September 29, 2010

Re: 16 Sterling Street, Peaks Island – 087 E021 – I-R2 – shed – permit #10-1160

I have done the zoning review for your permit to build a ten foot by twelve foot structure at your property at 16 Sterling Street, Peaks Island. Your application does not meet all the zoning requirements, so I must deny it.

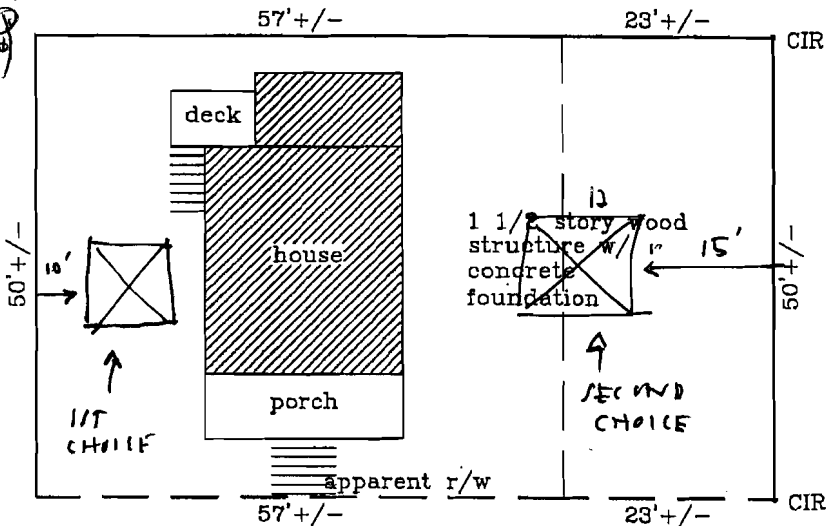
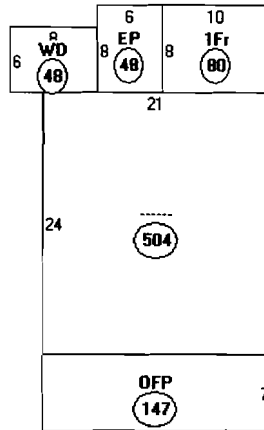
Your property is located in the I-R2 island residential zone. Section 14-145.11(d) states that you are allowed to cover twenty percent of your lot with the footprint of structures. Your lot is 4,250 square feet, so you can cover 850 square feet of it. Your present structure is 827 square feet. You are proposing to build a 120 square foot structure which would bring your total square footage to 947 square feet which covers 22.28% of the lot. Since this is over the maximum allowable twenty percent, I must deny your permit.

Also, the setbacks for the location of your proposed structure would have to be confirmed. The only setback given on the plot plan is the fifteen foot side setback which meets the requirement. You also appear to meet the ten foot rear setback. The front setback would have to be confirmed. It needs to be twenty-five feet or the average depth of the front yards on either side [section 14-145.11(c)(1)].
